Our Ref: AL/66/14/PD
Your Ref:

Application for Prior Notification for a commercial development

Development Prior Notification Under Class MB for change of use from agricultural building to 2 No. dwellinghouses (Use Class C3)
Location Sack Lane Dairy Sack Lane Lidsey

PROJECT			Conversion of existing barn at Sack Lane Dairy, Lidsey	
SUBJECT				
Site Plan and Location Plan				
SCALE	DATE	DRAWING NO	Rev	
1/200 A 1: 1250	Mar 2013		A	
DRAWN	CHECKED	2012/01/11

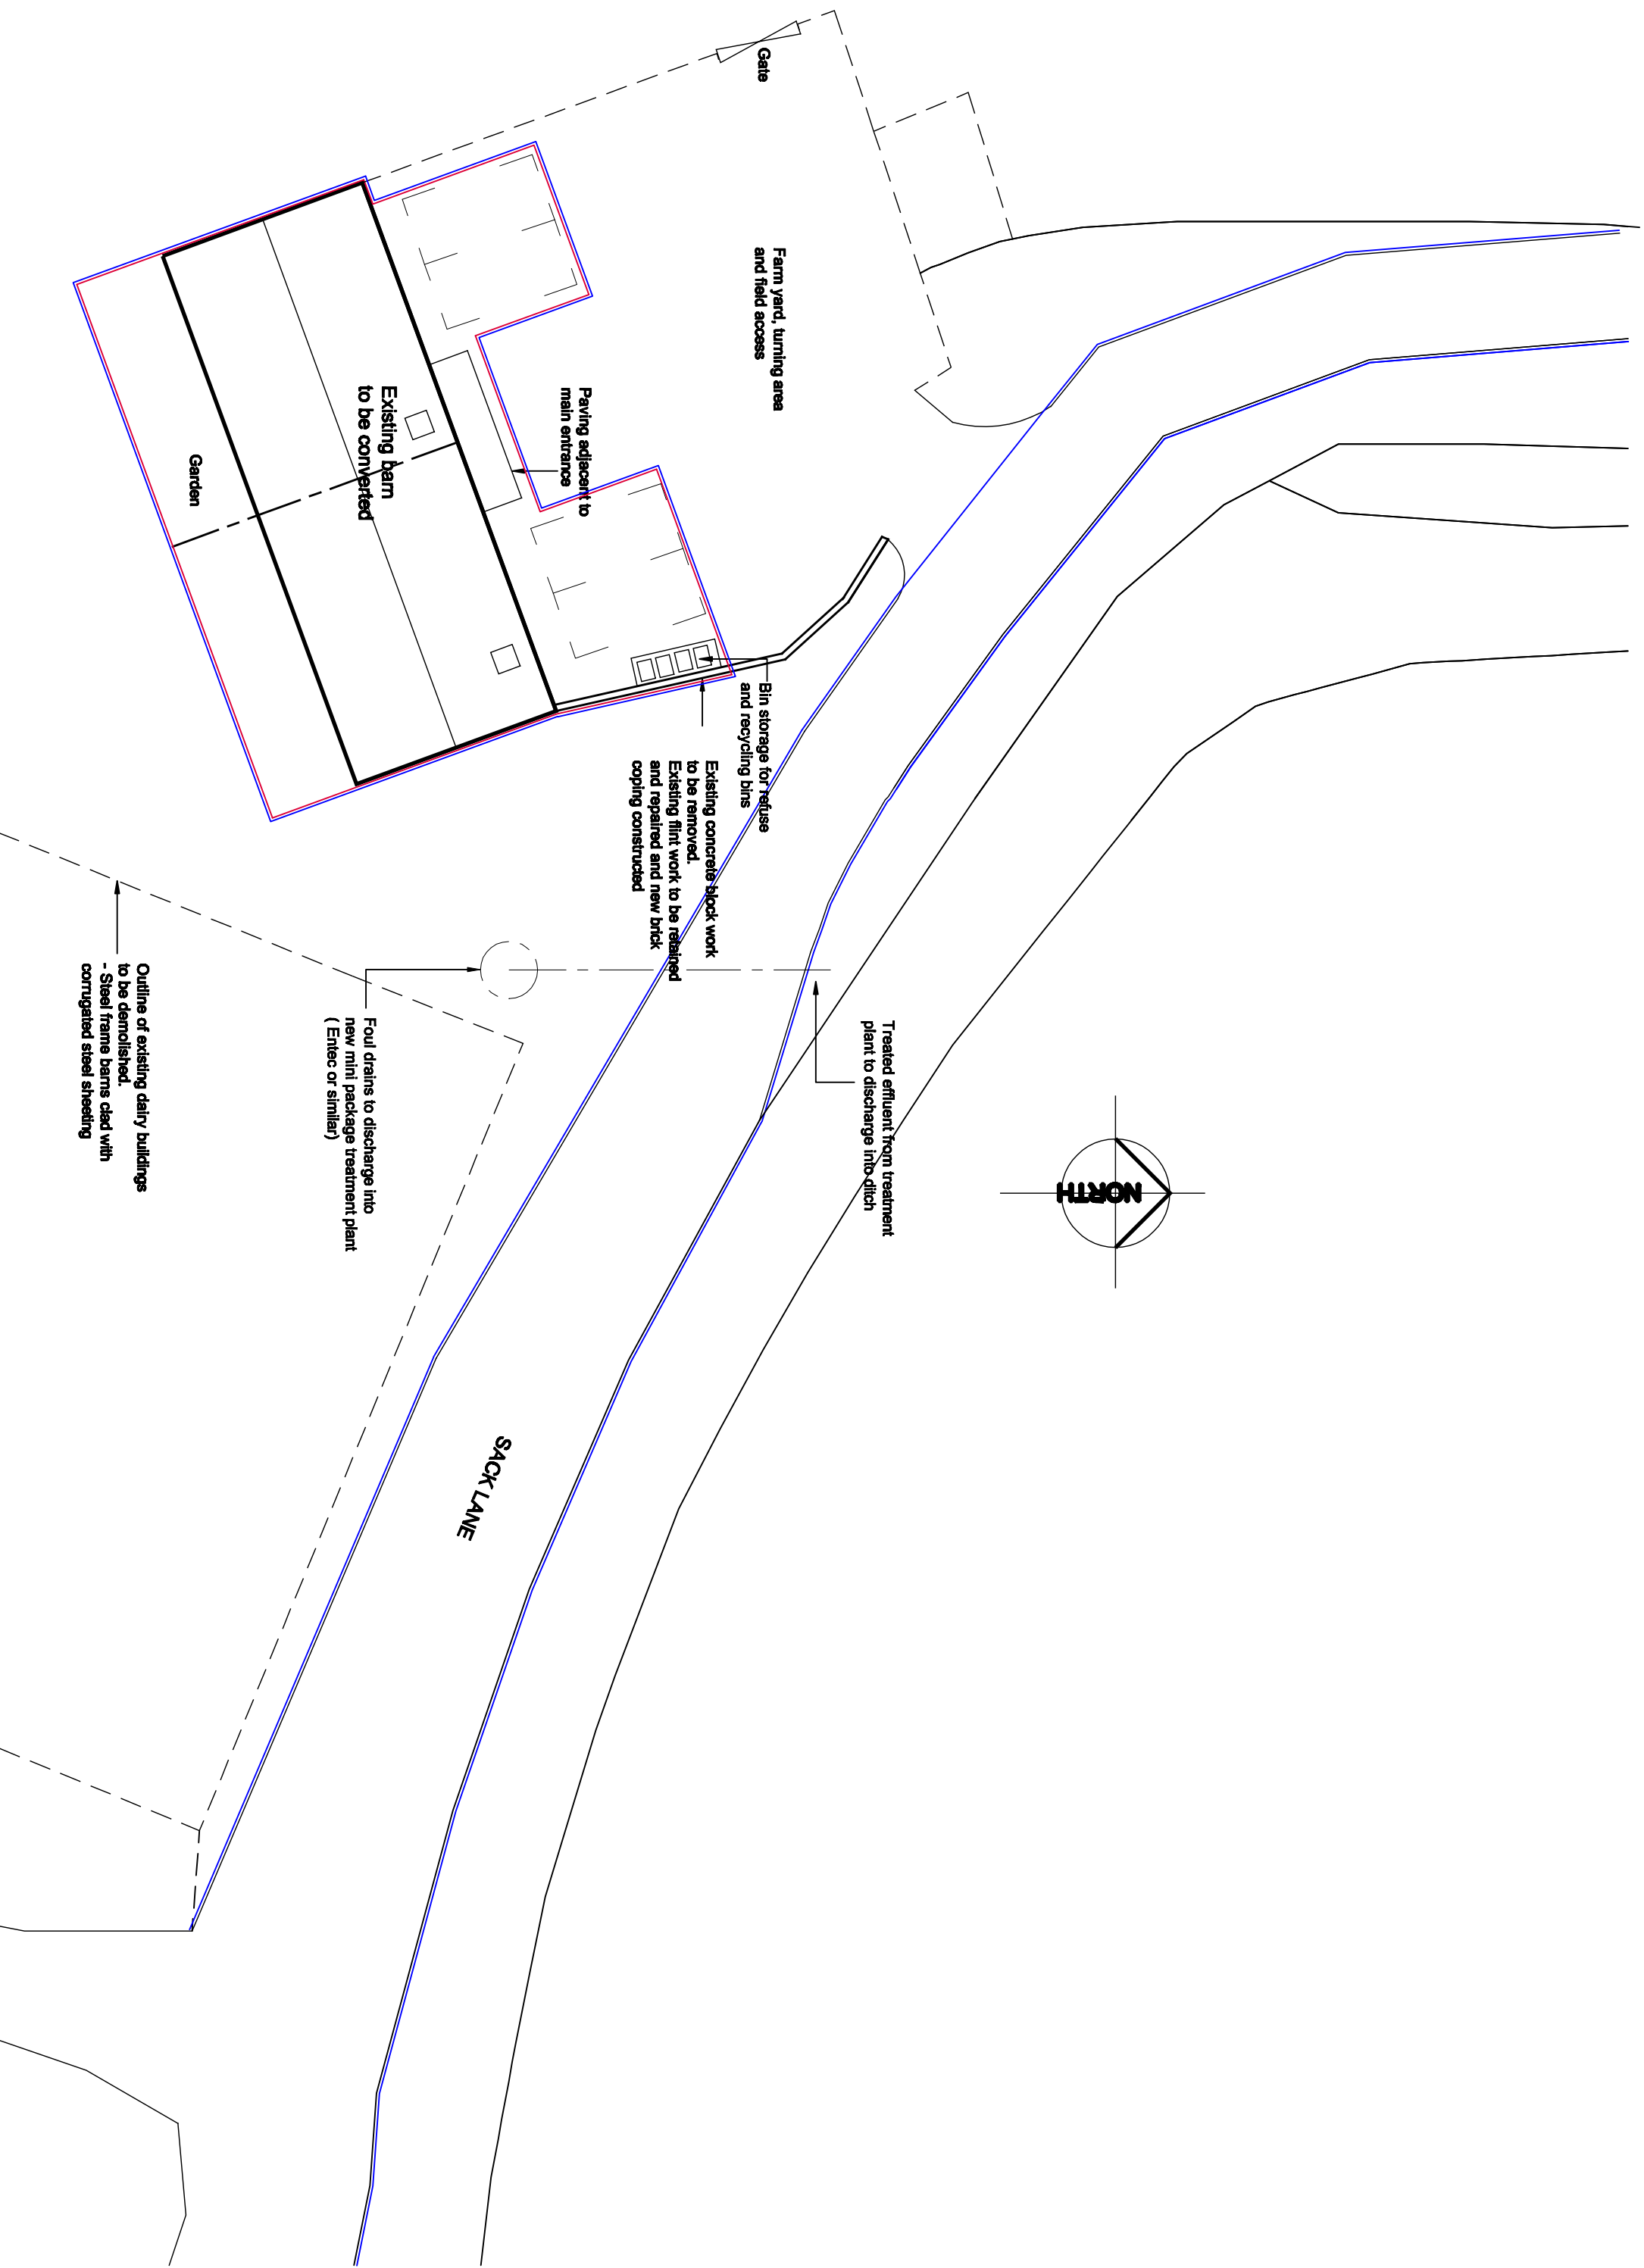
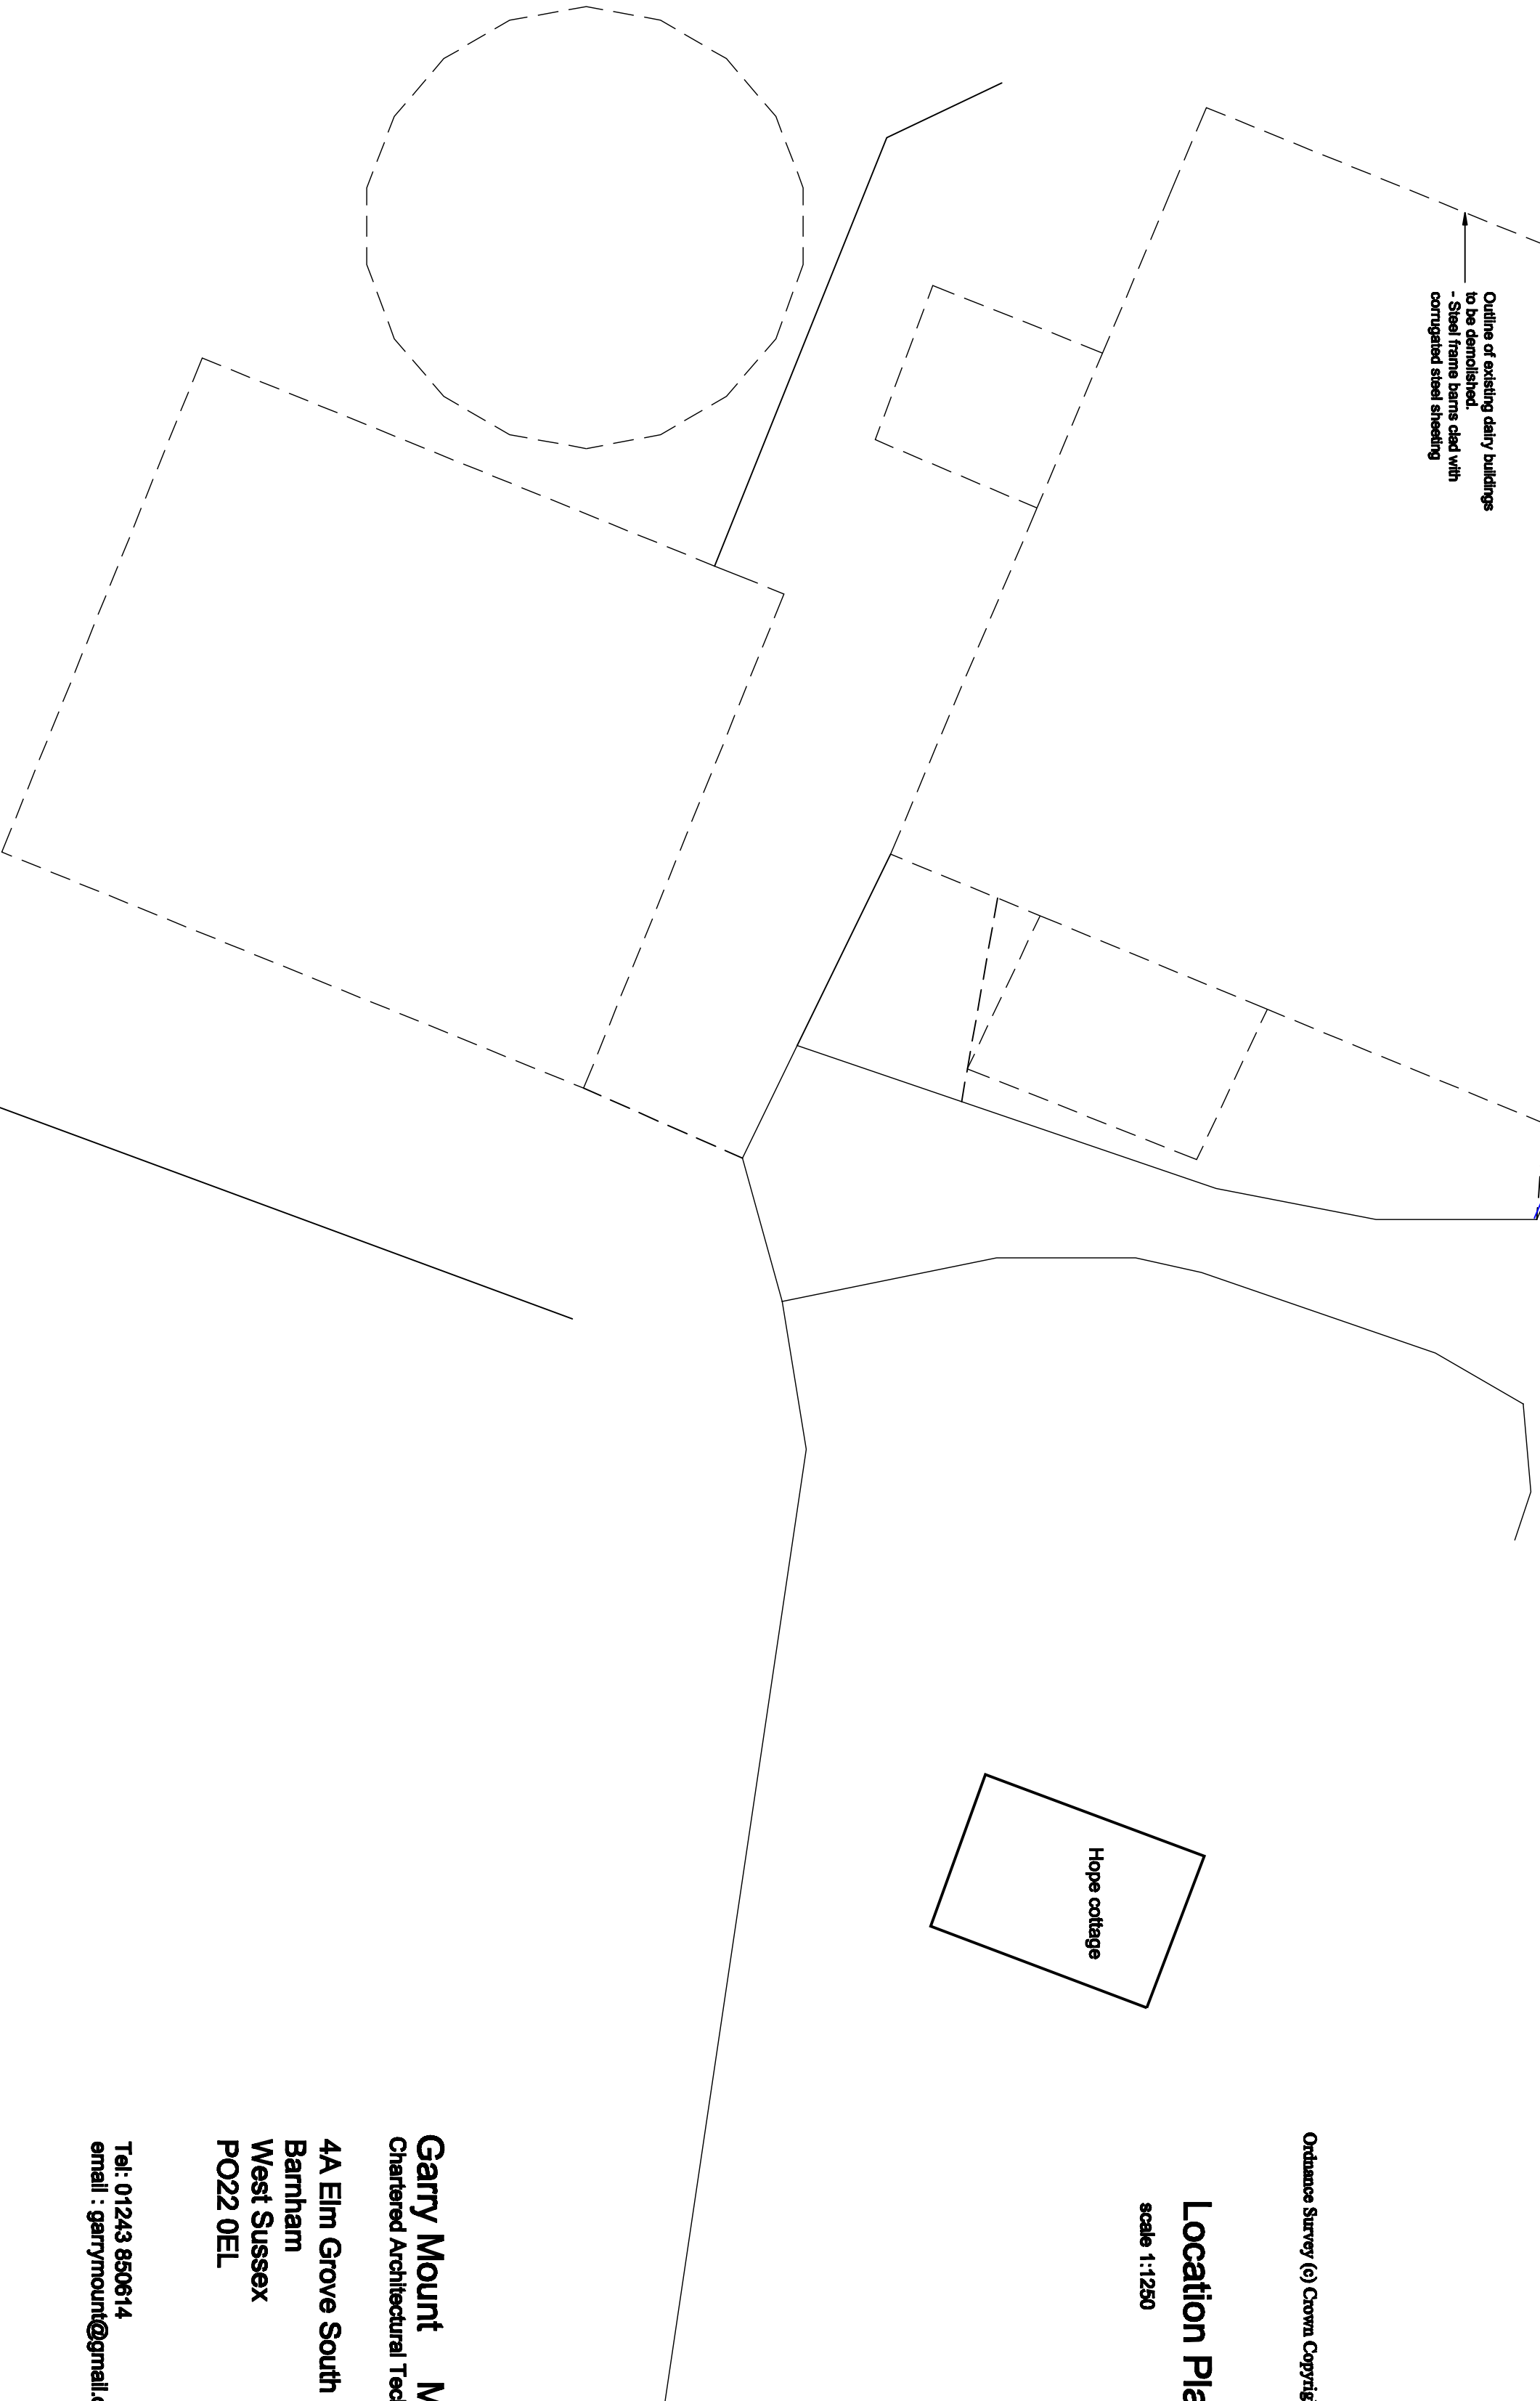
1. The position of the conservation light to the bathroom of the 2 bedroom unit shown on the roof plan does not coincide with the location shown on the floor plan.
2. Curtilage - The area of land immediately beside or around the building should not be larger than the land area occupied by the agricultural building. (See GPDO 1995 (as amended) Interpretation of Part 3)
Therefore, please submit amended plans accordingly.
